**Your  
Reference** SSD-35609161

**Our  
Reference** NCA/6/2022

30 August 2022

**City of Parramatta Council submission to State Significant Development Application for a mixed-use building, including 'Build to Rent' units at 12 Hassall Street, Parramatta**

Title
B-GENERAL ARRANGEMENT PLANS
BASEMENT LEVEL 5 FLOOR PLAN

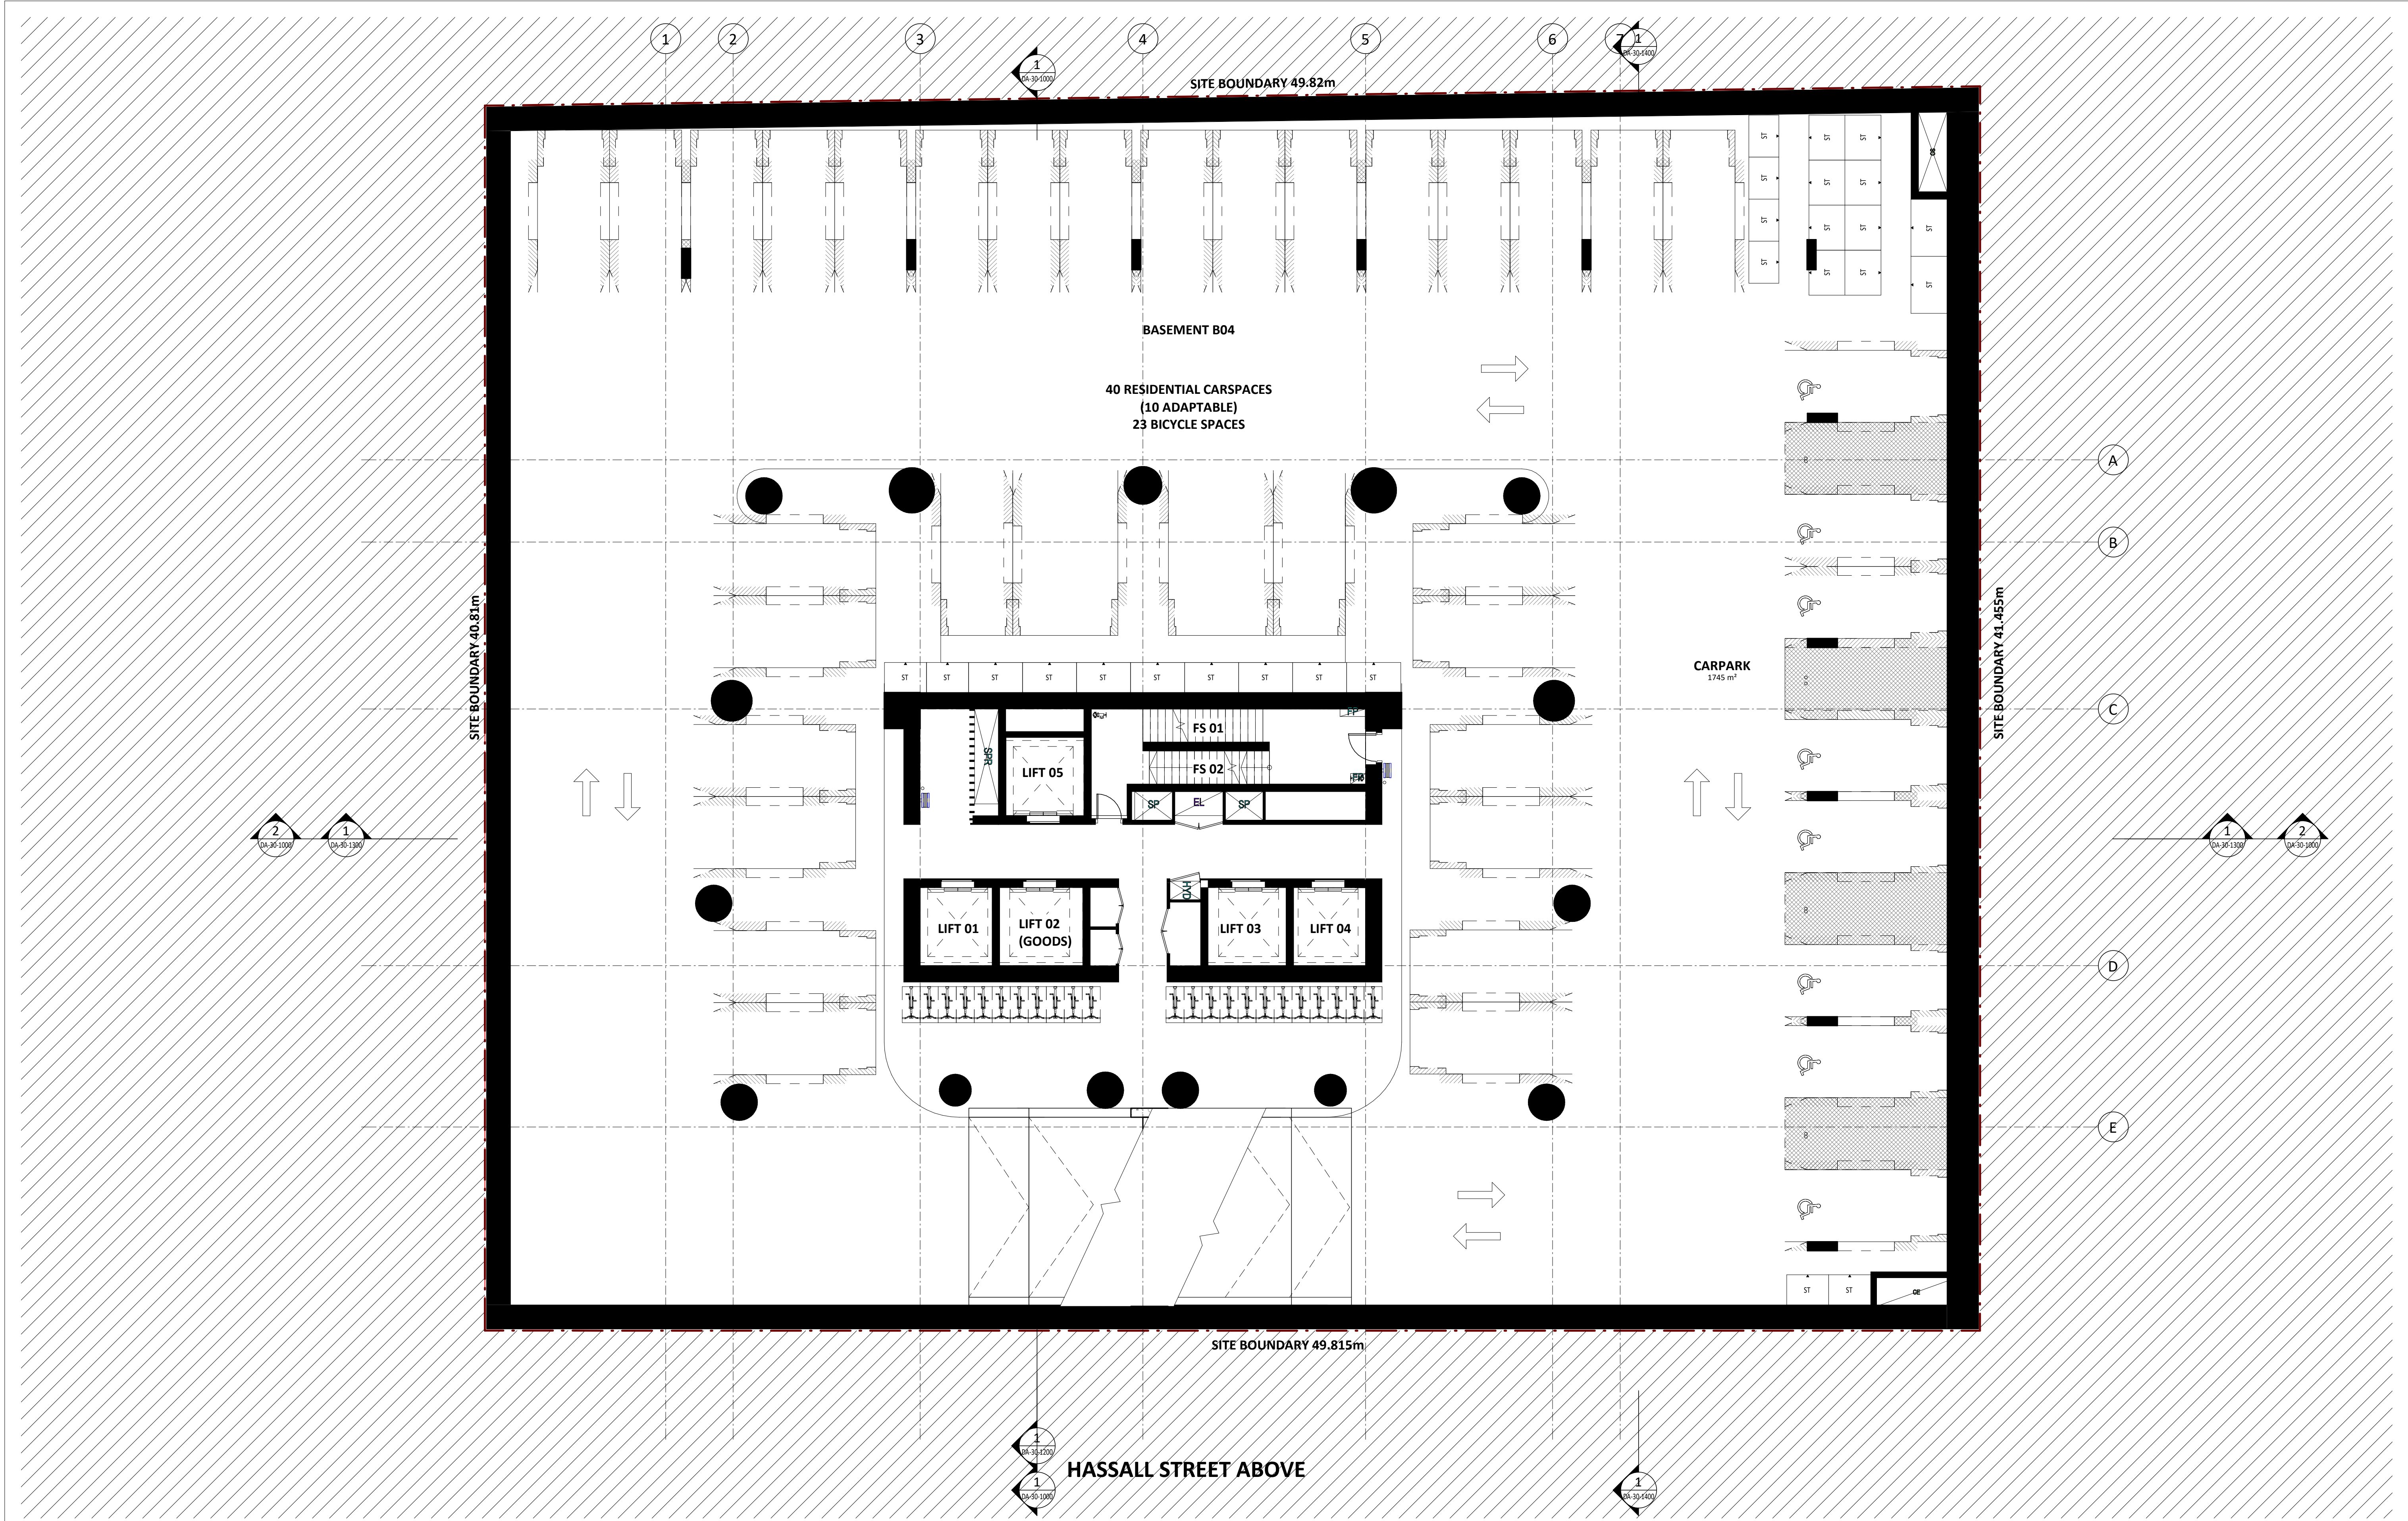
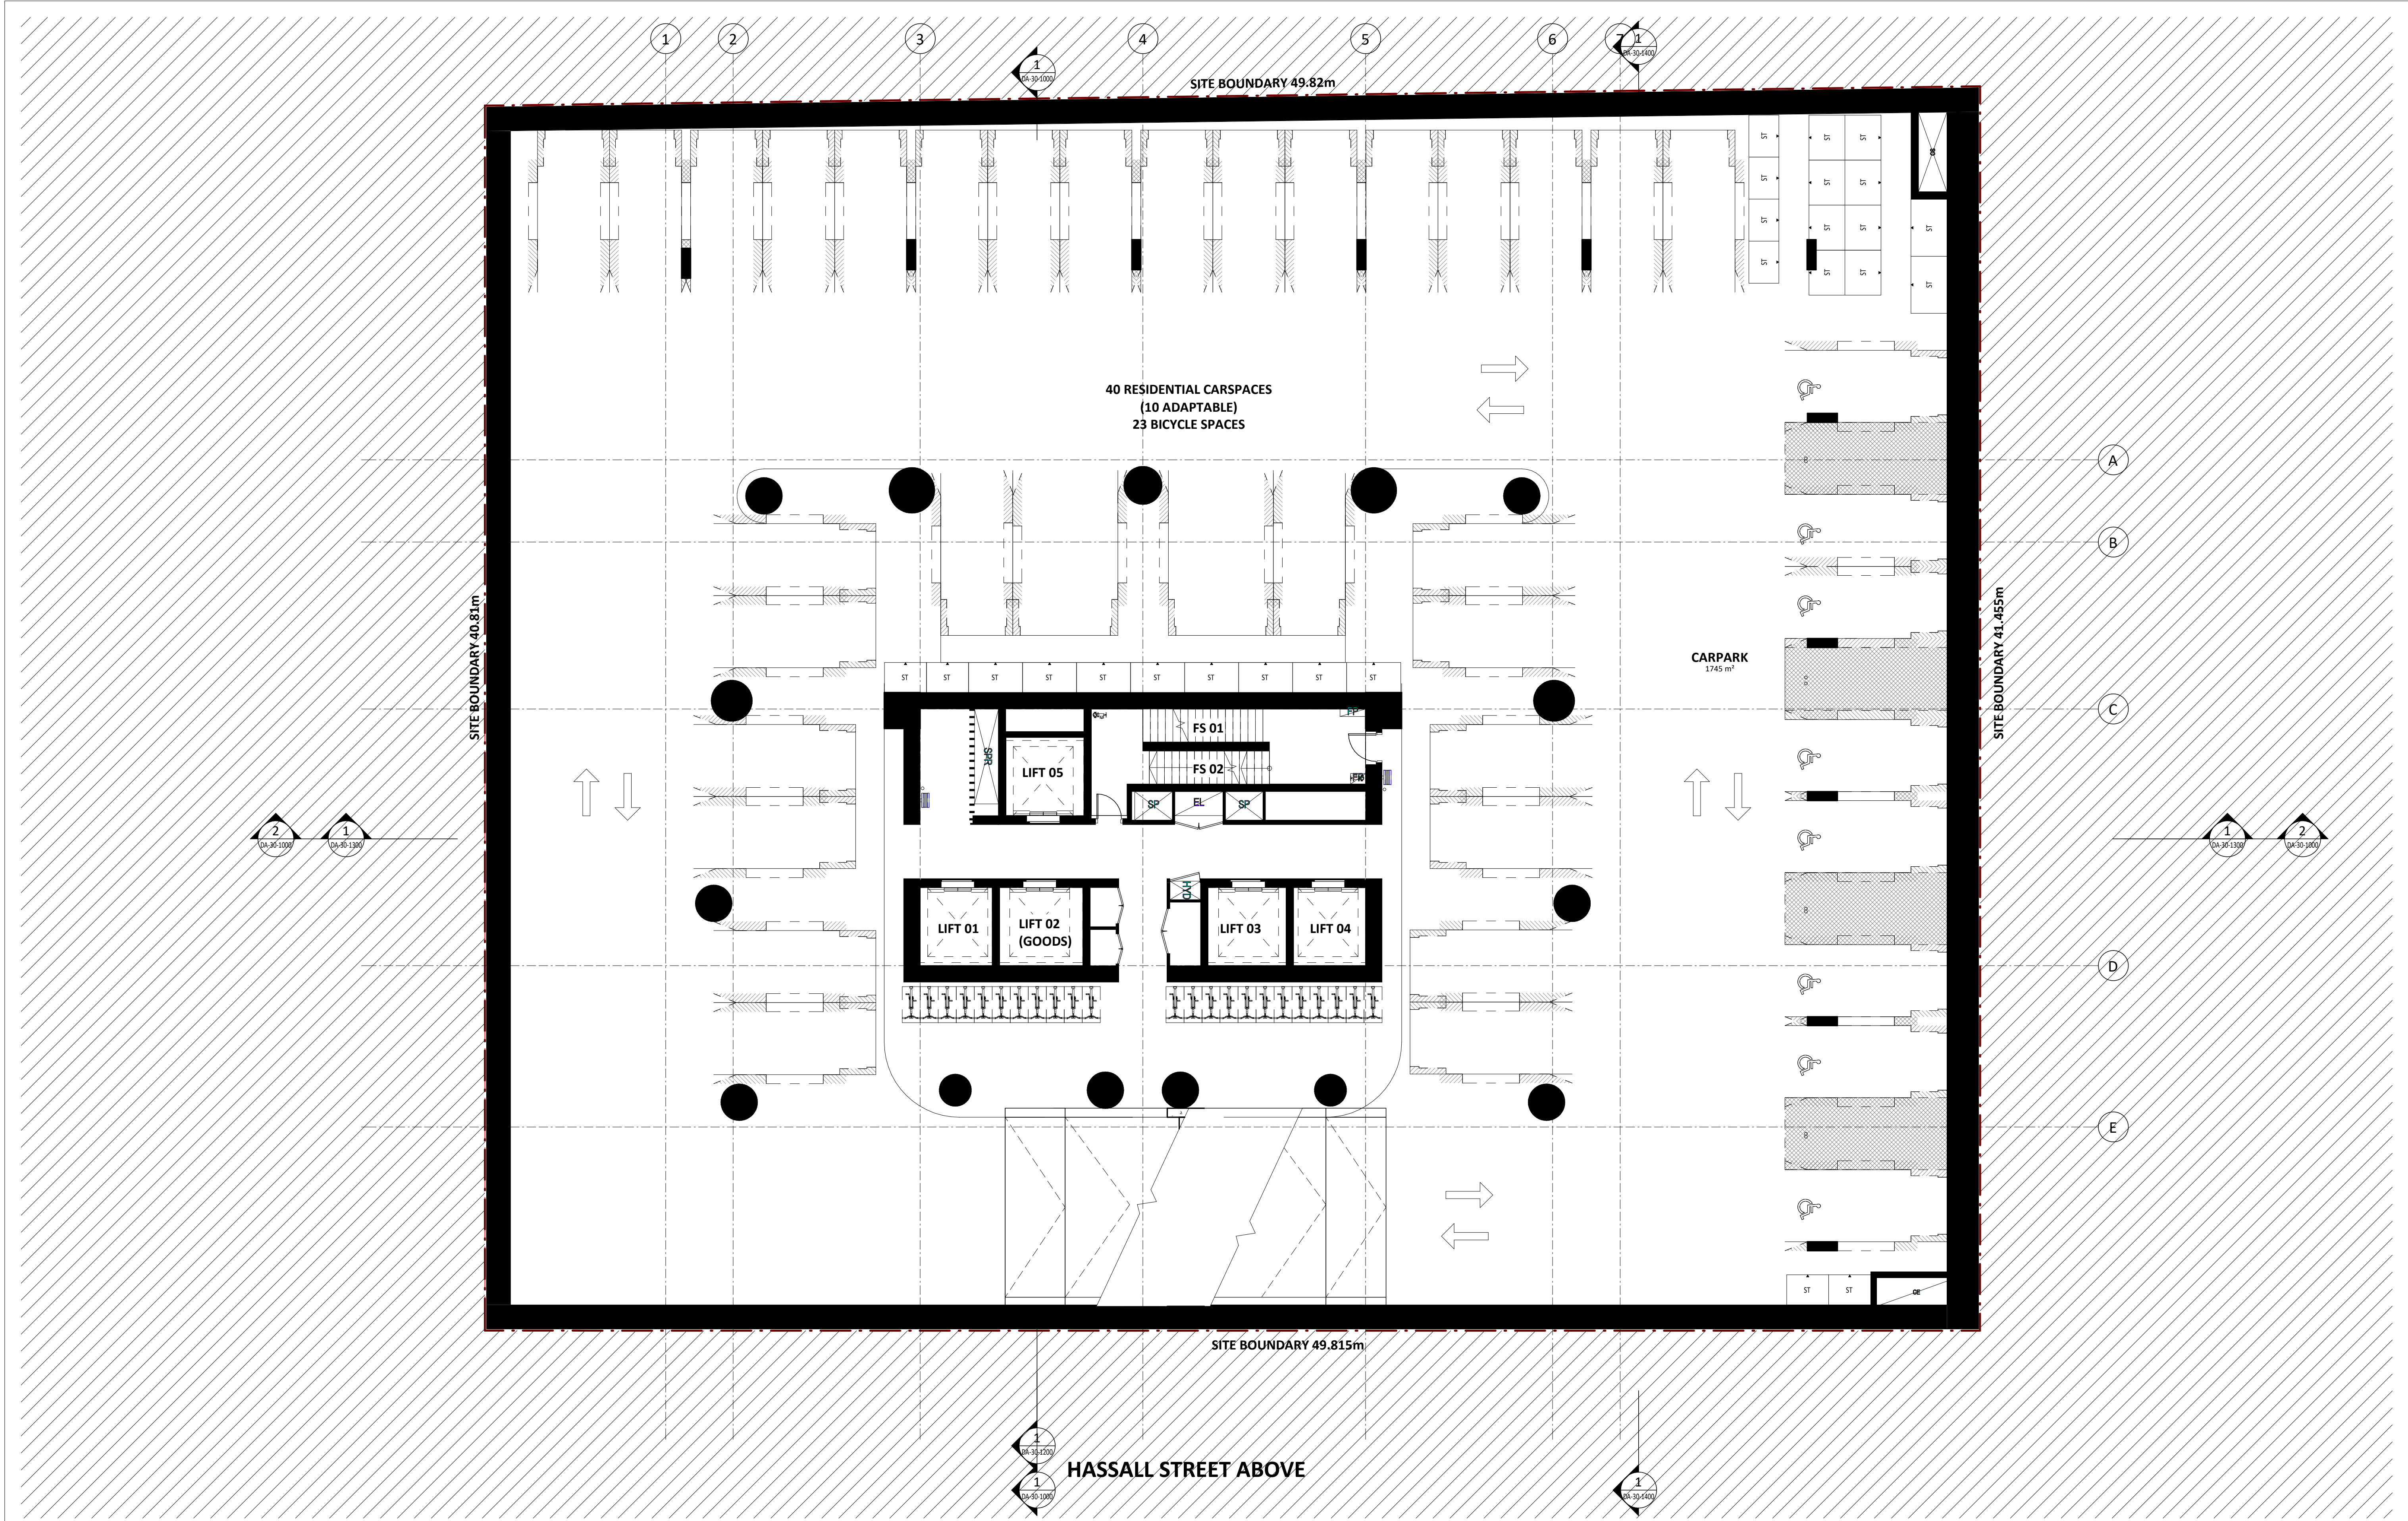
The basement plans should be amended to include the provision of lockers to support the end of trip facilities as per the requirements of Amendment 56 of the Parramatta LEP 2011.
